Response to Planning Application

Application ref: Y/71/20/RES

Description: Approval of reserved matters following outline consent Y/88/18/OUT for the erection of 38 No. dwellings

Location: Land North of Yapton Church of England Primary School North End Road Yapton

DRAWING NUMBER:
DD427L06

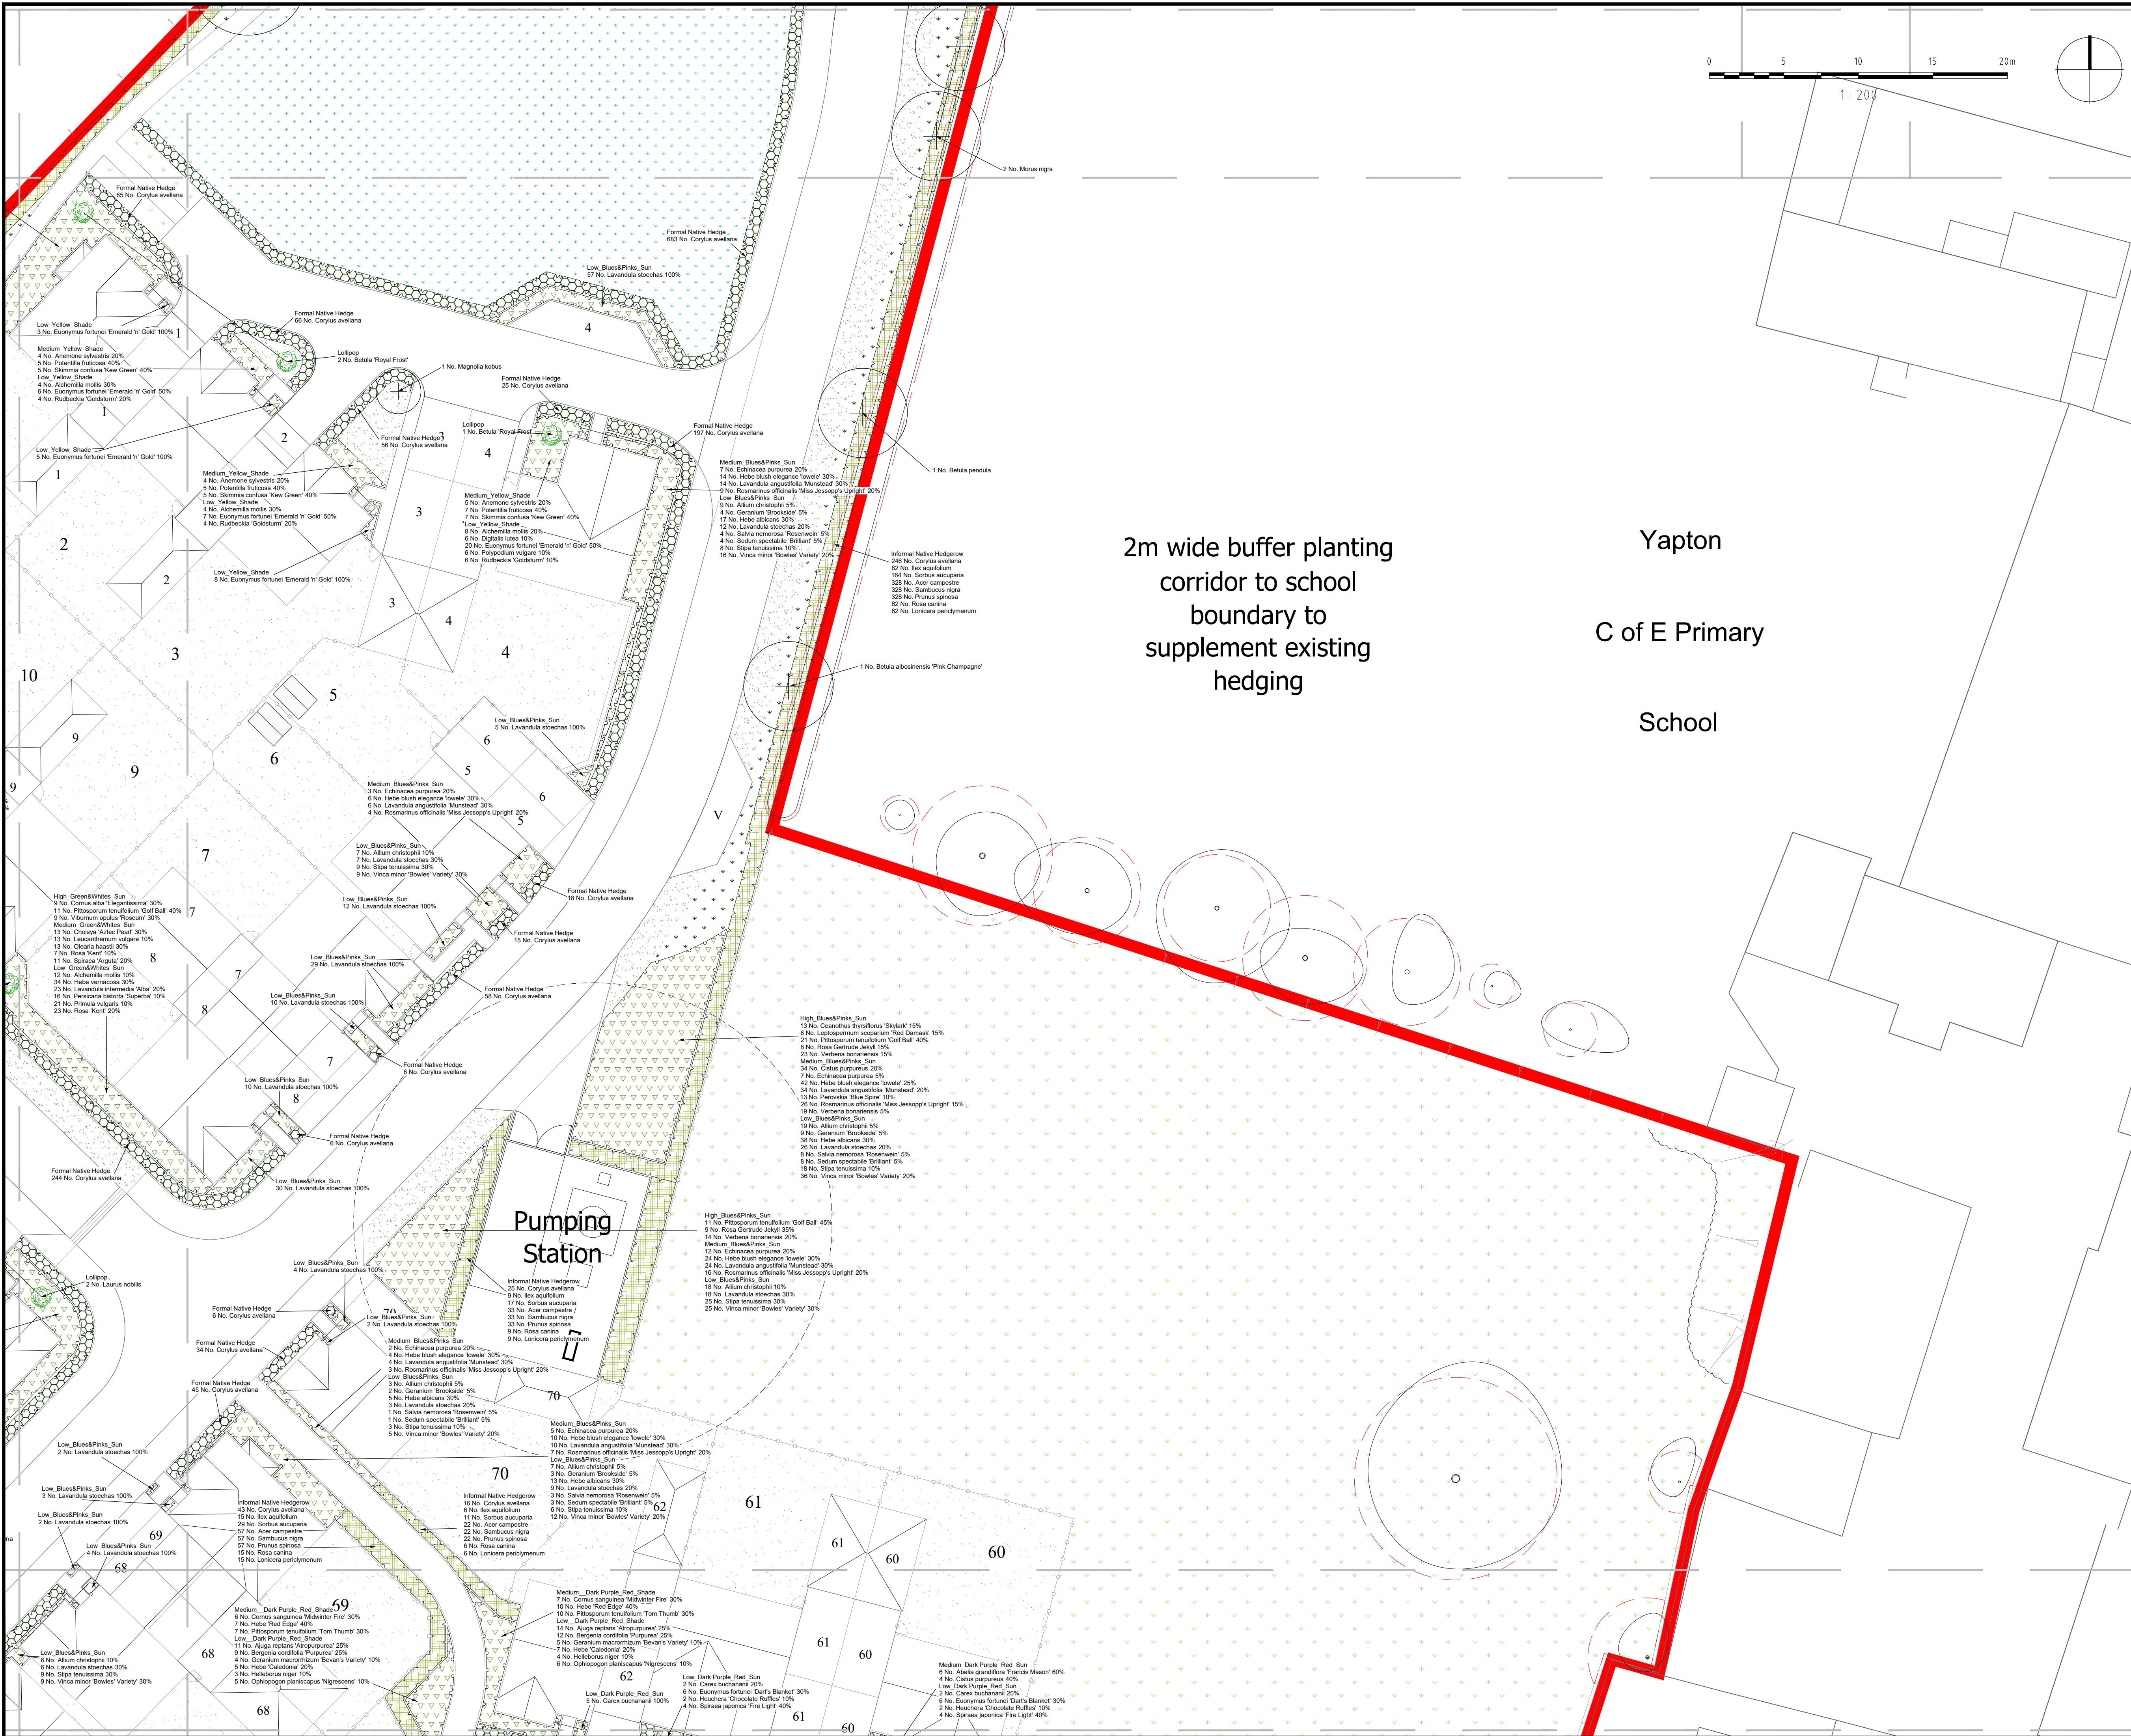
In general the detailed landscape proposals have shown a scheme which would be fitting for location in species choice, planting densities and size at time of planting. Given adequate maintenance these proposals should mature to form a scheme which is fitting for location and enhances the setting of the development. I would however raise for clarification the following points:
